1/6/2025

David Gutierrez, PE
Albuquerque Bernillo County
Water Utility Authority

Re: ***2nd Review - PR-2024-009956 Taco Bell
Comment Responses to Utility Development Review***

UTILITY PLAN

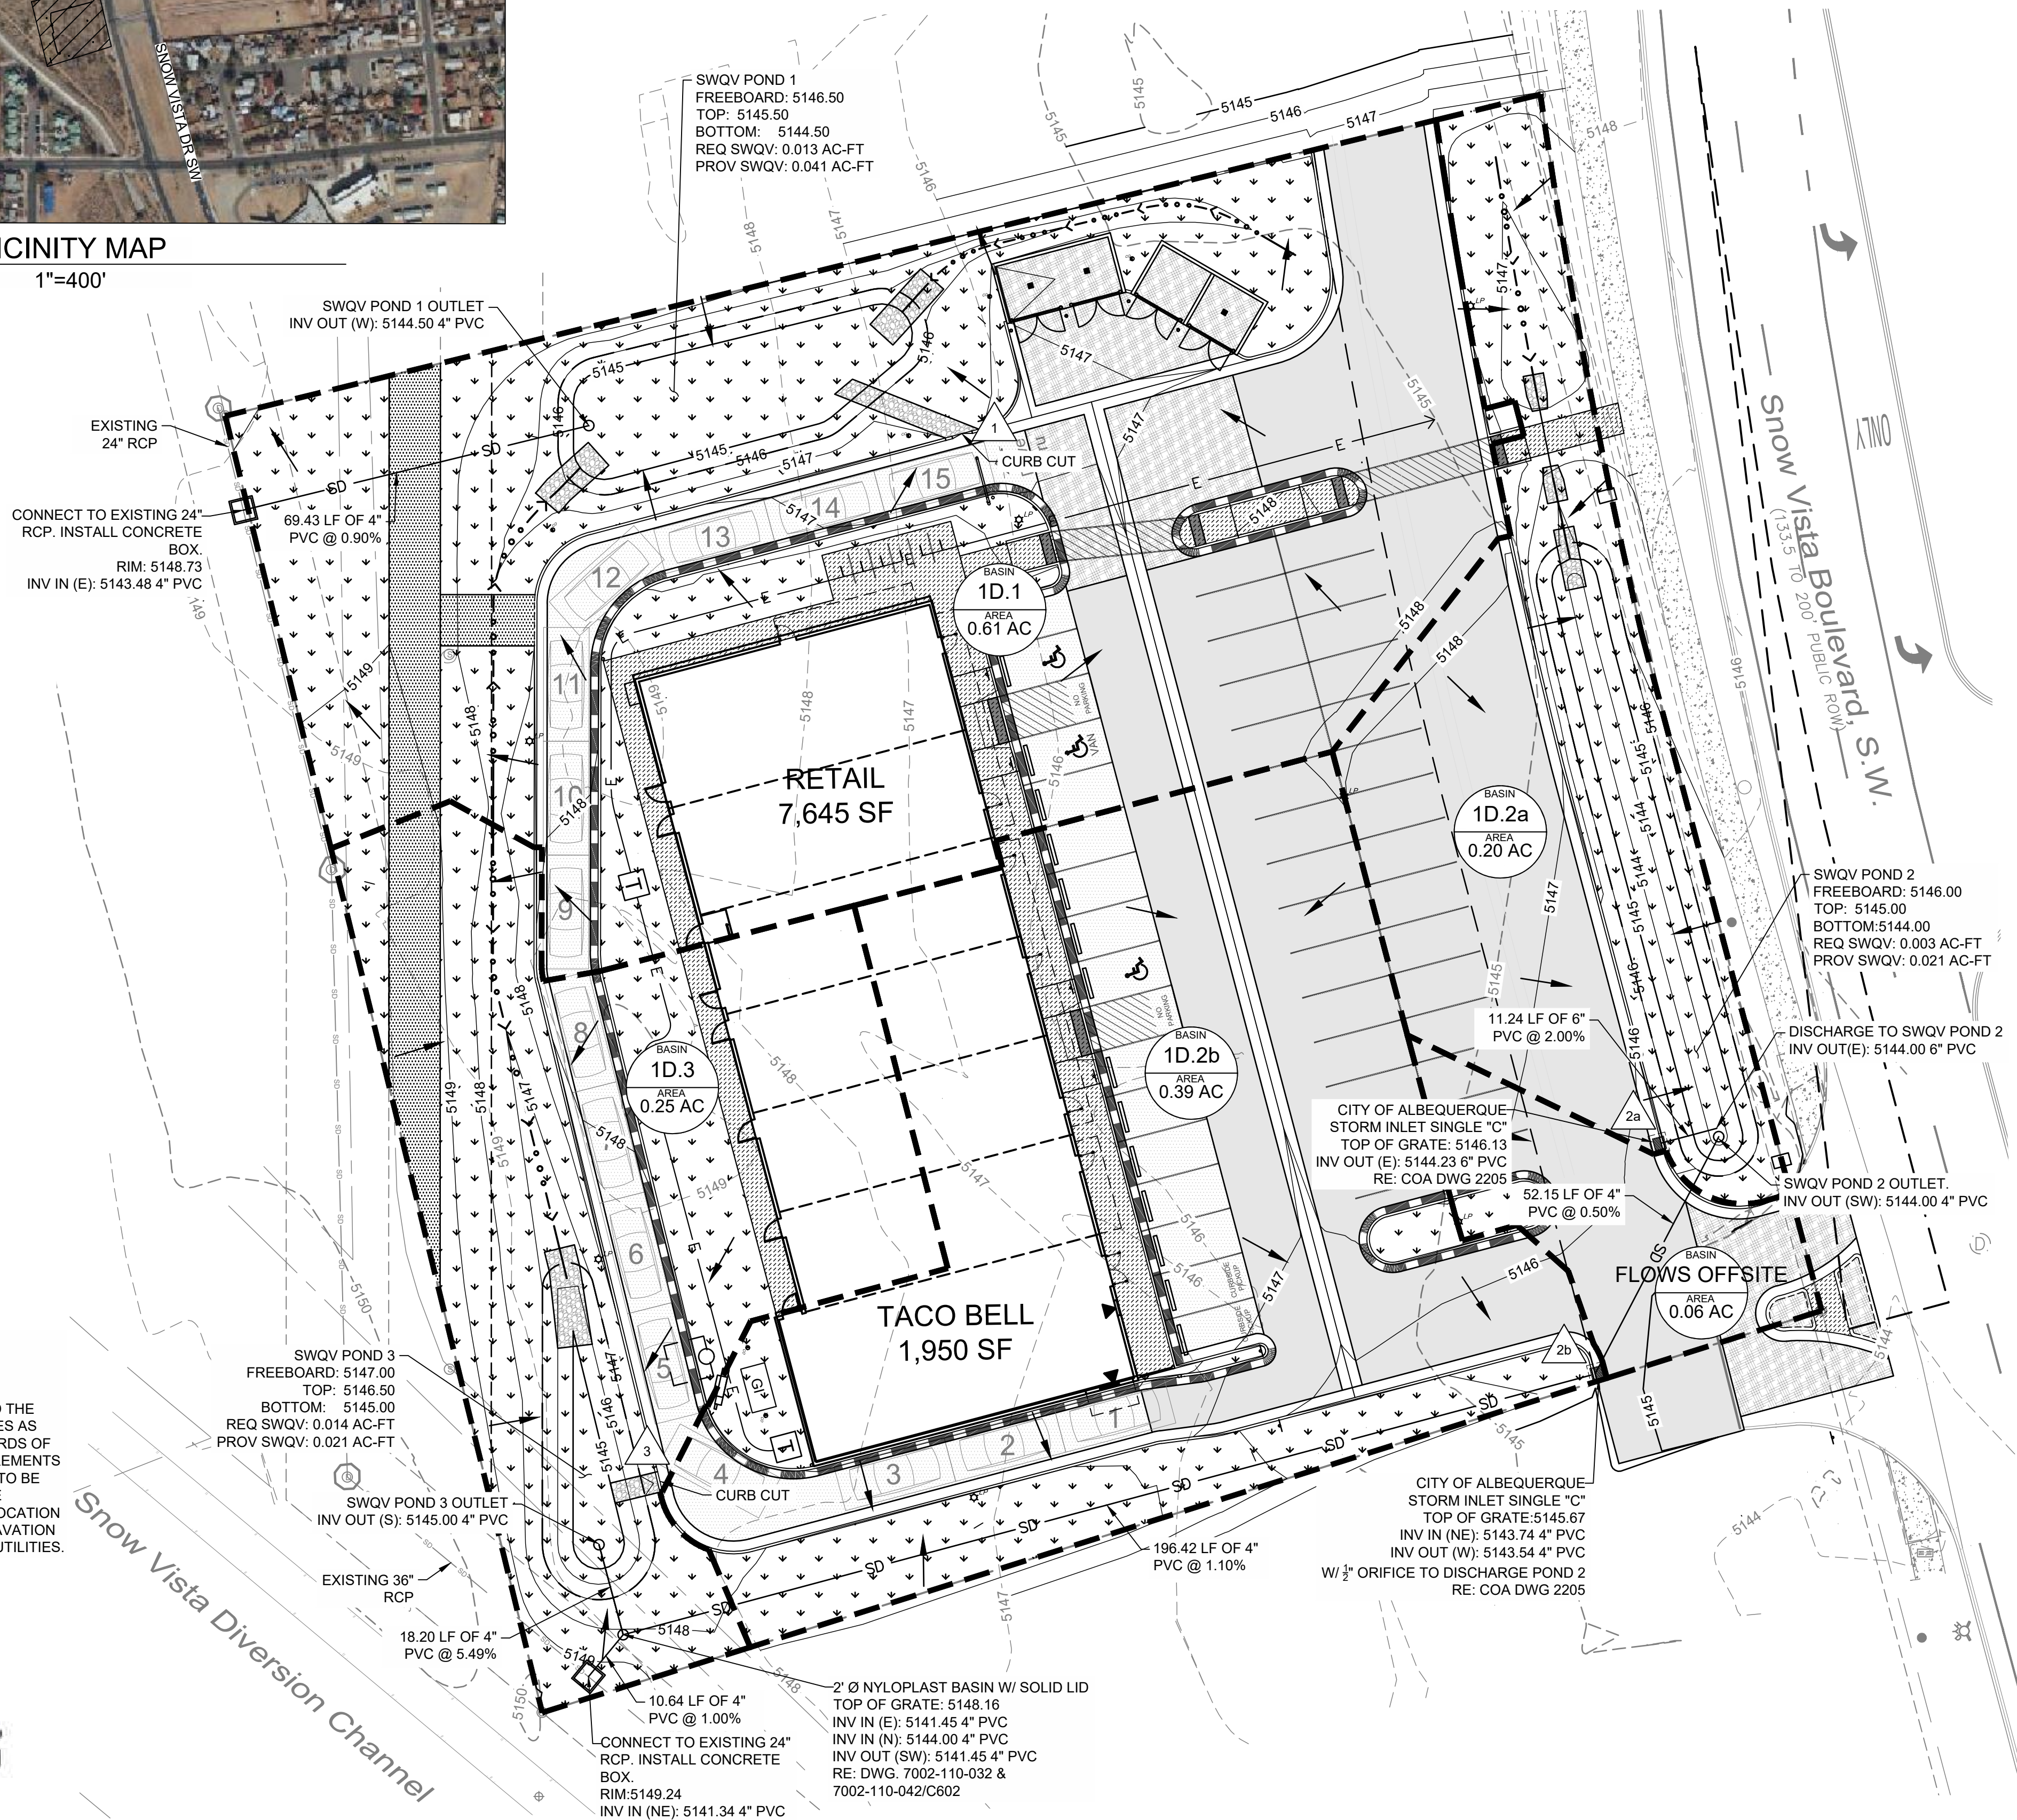
1. The easement for the existing sanitary sewer line is insufficient as it is on the border. Additional easement will need to be granted for this prior to any approvals.

a. There is currently a sanitary sewer line that runs through the site that is shown that must maintain a clear corridor free from any trees, or major landscaping that would inhibit operation and maintenance of the line.

b. There is an existing manhole on the site that needs to be shown and access must be provided for a vactor truck to be able to back up directly to for maintenance purposes. Please provide this access and show it on the plans.

c. Provide a utility plan that indicates the location of proposed services.

d. Show existing public water and public sewer mains and any associated easements on the utility plan.

- e. Dimension the public water and public sewer easements on the utility plan.
 - **Response: The public sewer easement is shown and dimensioned on the utility plan. The public water line is located within the right-of-way.**

- h. Please add the following notes to the Master Utility Plan
 - i. Coordination with Water Authority Cross Connection Section will be required to ensure proper backflow containment is in place prior to release of meter for the site. Contact the Cross Connection Section at 505-289-3454.

- **Response: A new 20' easement will be dedicated that will center the existing sanitary sewer line within the limits of the property.**

- **Response: A proposed 10' wide corridor has been provided for maintenance of the existing sanitary sewer line. Major landscaping or trees will not be proposed within the limits of the corridor.**

- **Response: A proposed 10' wide corridor has been provided for maintenance of the existing sanitary sewer line and manhole.**

- **Response: The proposed services are located on the plans.**

- **Response: The existing 20' sanitary sewer easement and the existing sanitary line is shown and labeled on the plans.**

- **Response: Note has been added to the utility plan.**
 - ii. Coordination with the Water Authority Pre-Treatment Engineer is required to ensure the site complies with Water Authority Sewer Use Ordinance. Contact the Pre-Treatment Engineer at 505-289-3439.

- **Response: Note has been added to the utility plan.**
